From: Juan Baeza <[REDACTED]>
Sent: 06 December 2018 12:04
To: David Bennett
Subject: RE: 2 Hillview Crescent - EP/41/18/PDH

Turning to your suggestion I agree that this would seem an acceptable compromise to overcome the objections raised by EP/150/17/HH and EP/44/18/18/HH and harming the street scene to Orchard Road. I would add that your proposed north dormer would need to demonstrate no unacceptable overlooking as would be the requirement if it was to be constructed as PD.

A solution would be to grant planning permission at No. 2 Hillview Crescent for a hip-to-gable on the west elevation with a dormer on the north elevation with a condition removing PD rights relating to the south elevation.

DRAWING TITLE
Proposed Elevations

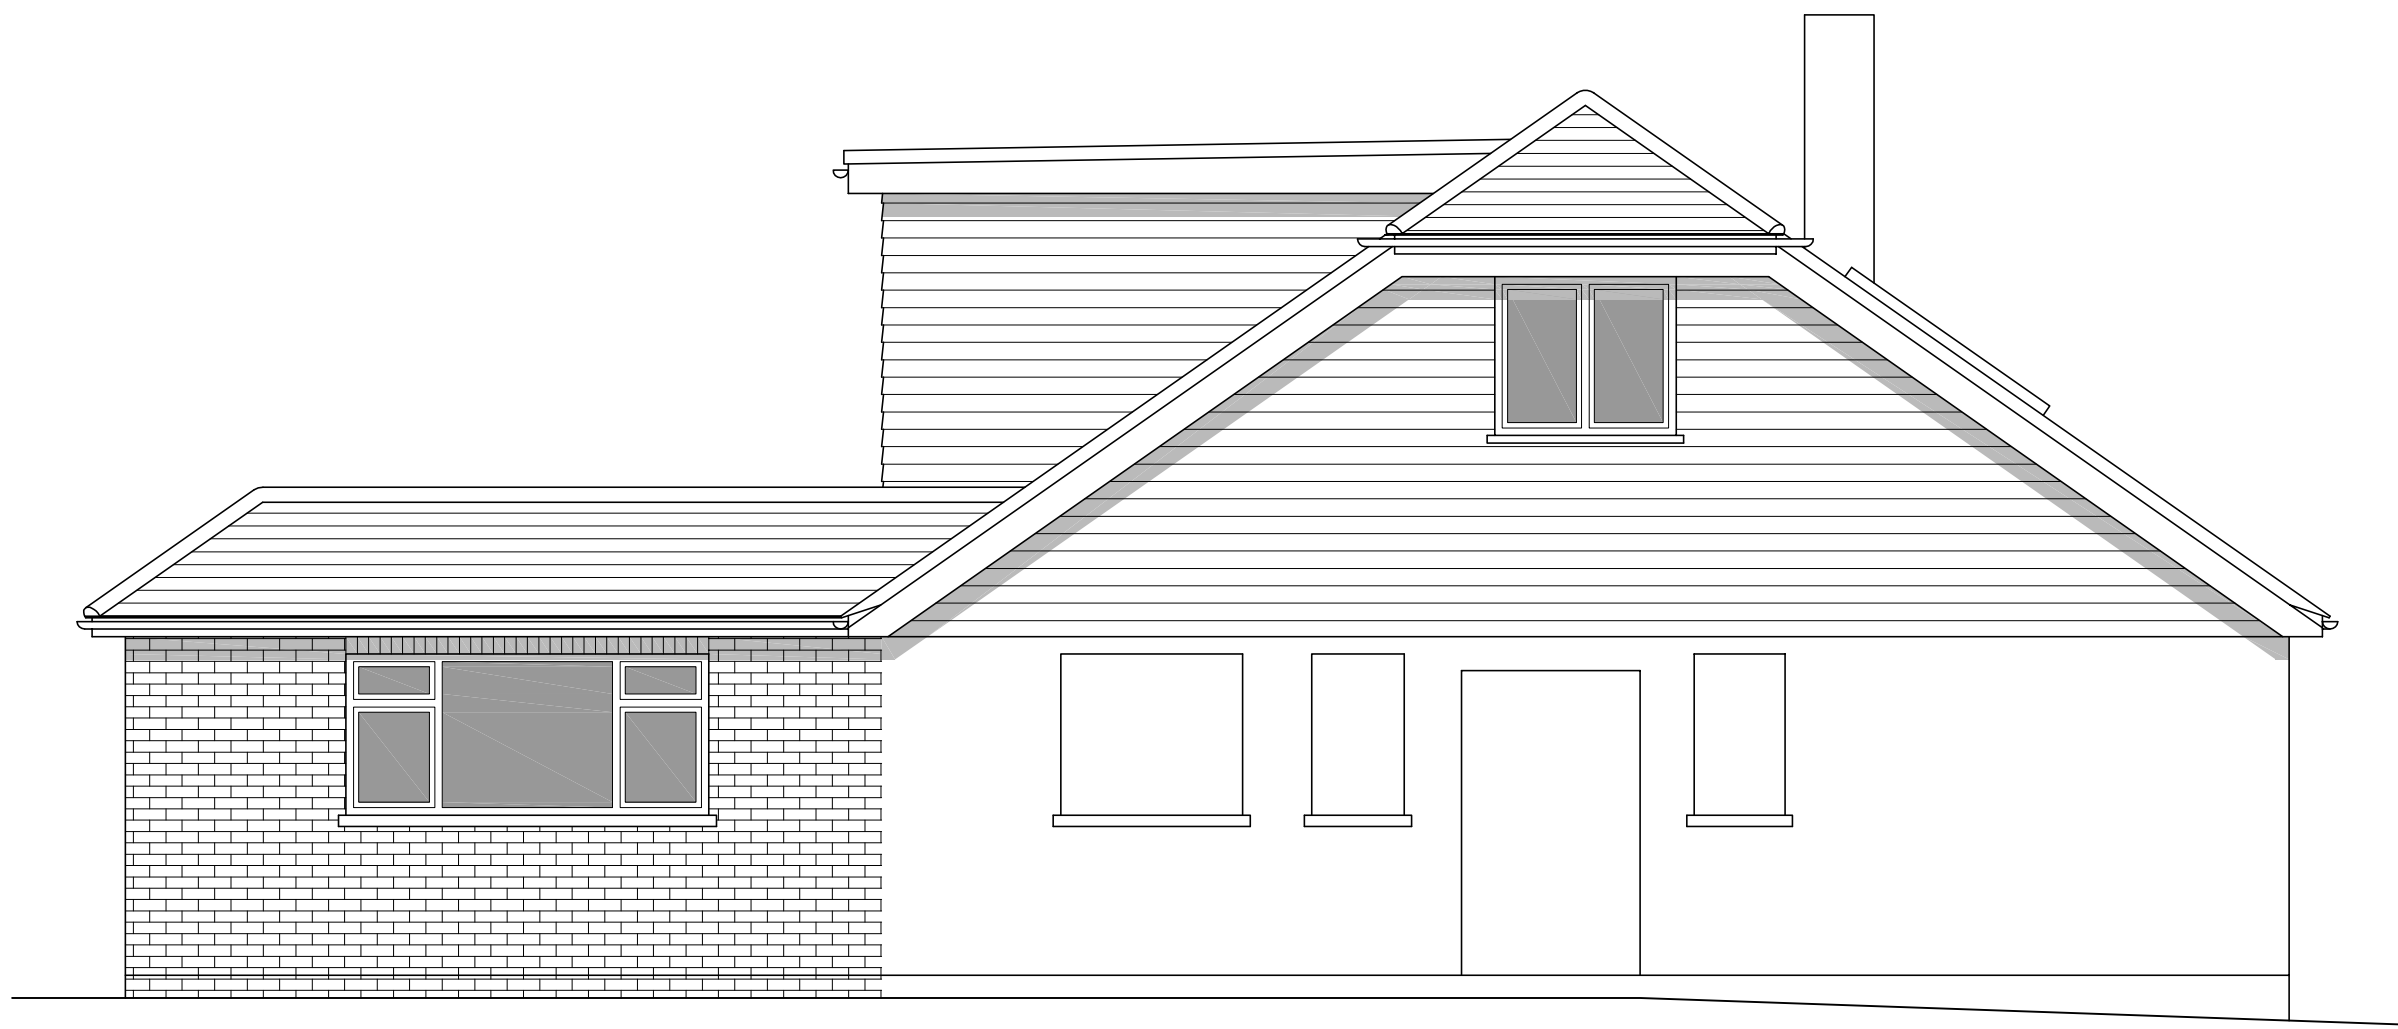
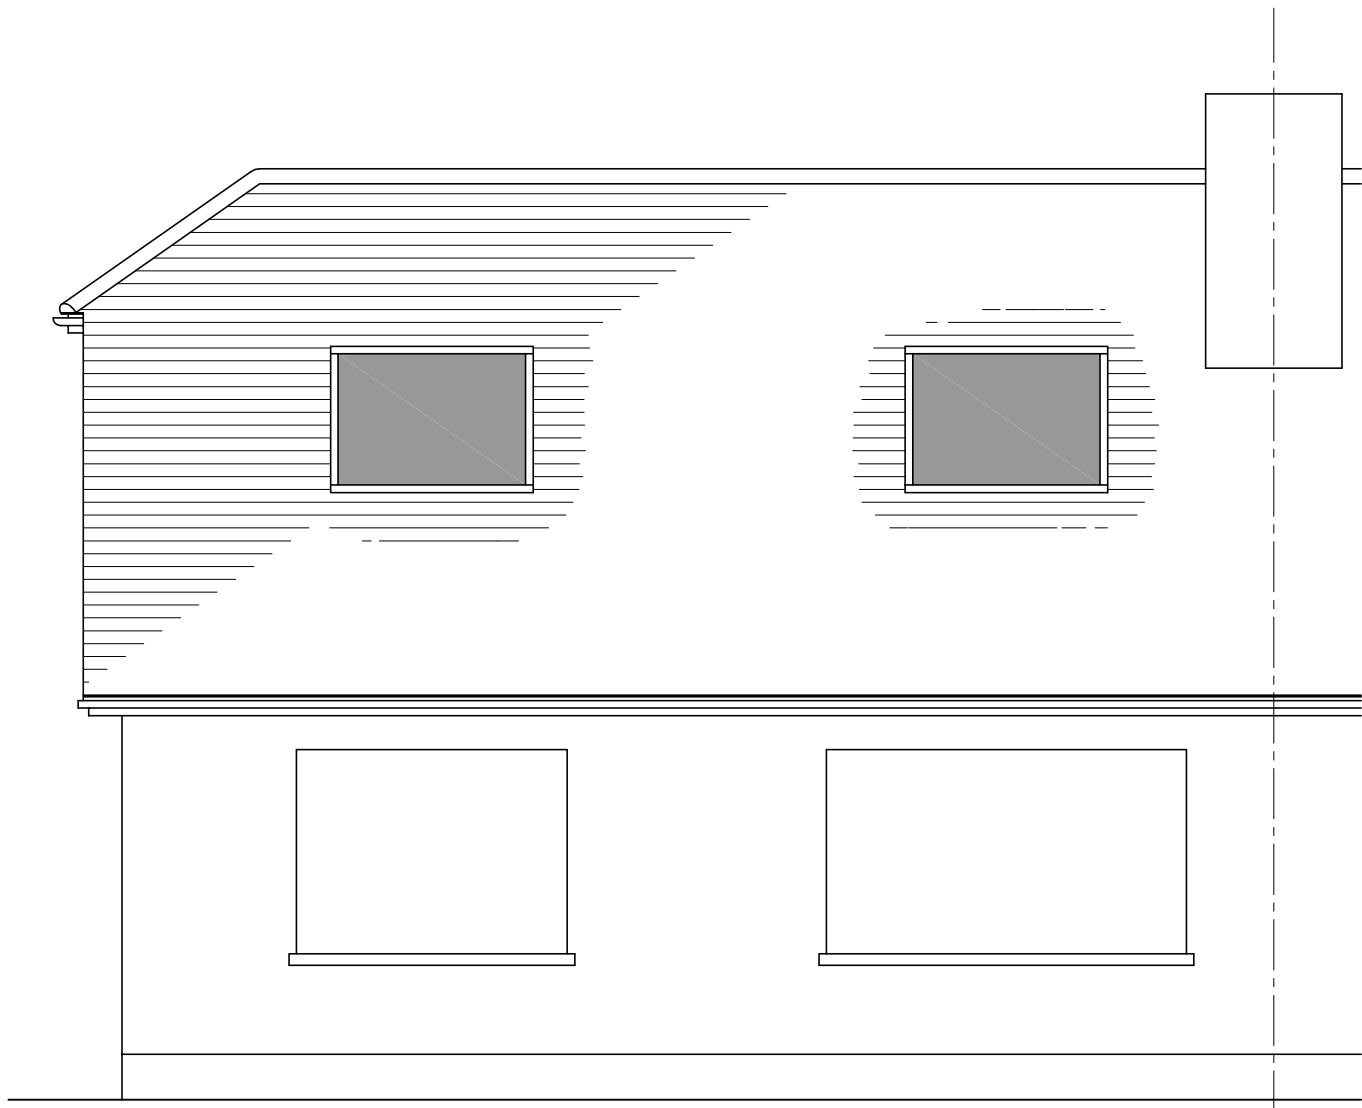
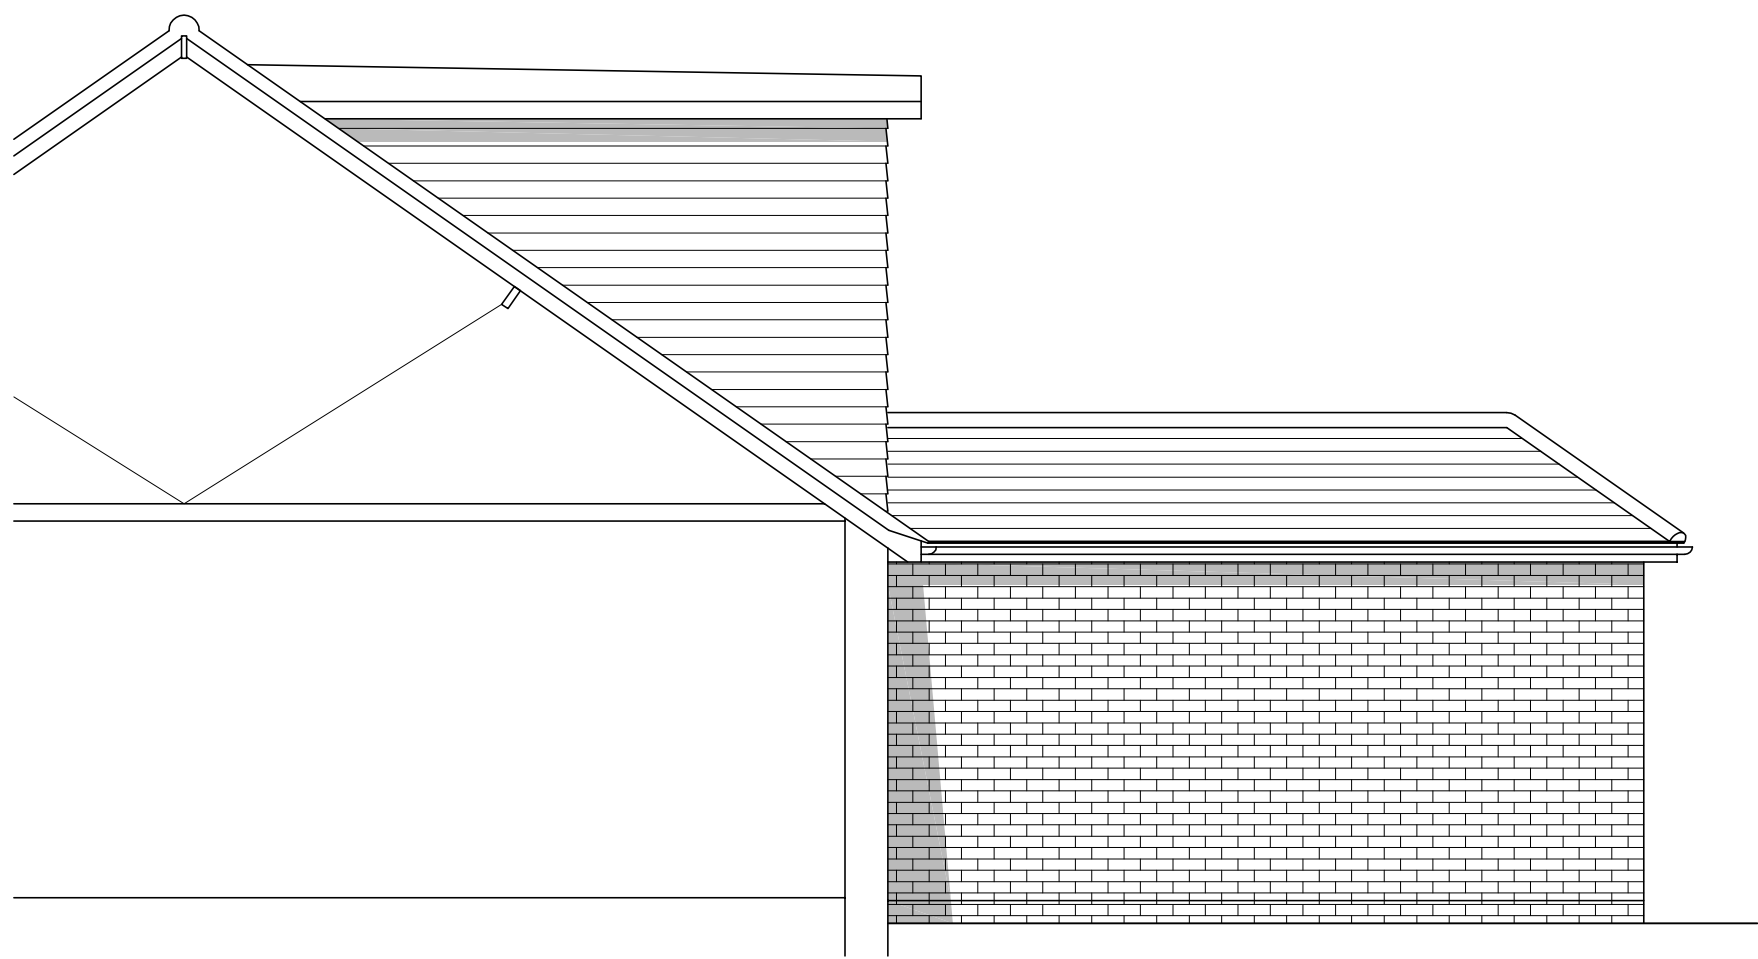
So just to clarify the west hip-to-gable in lieu of south dormer - please confirm.

Confirmed. I trust like previous applications it will have a hip bonnet?
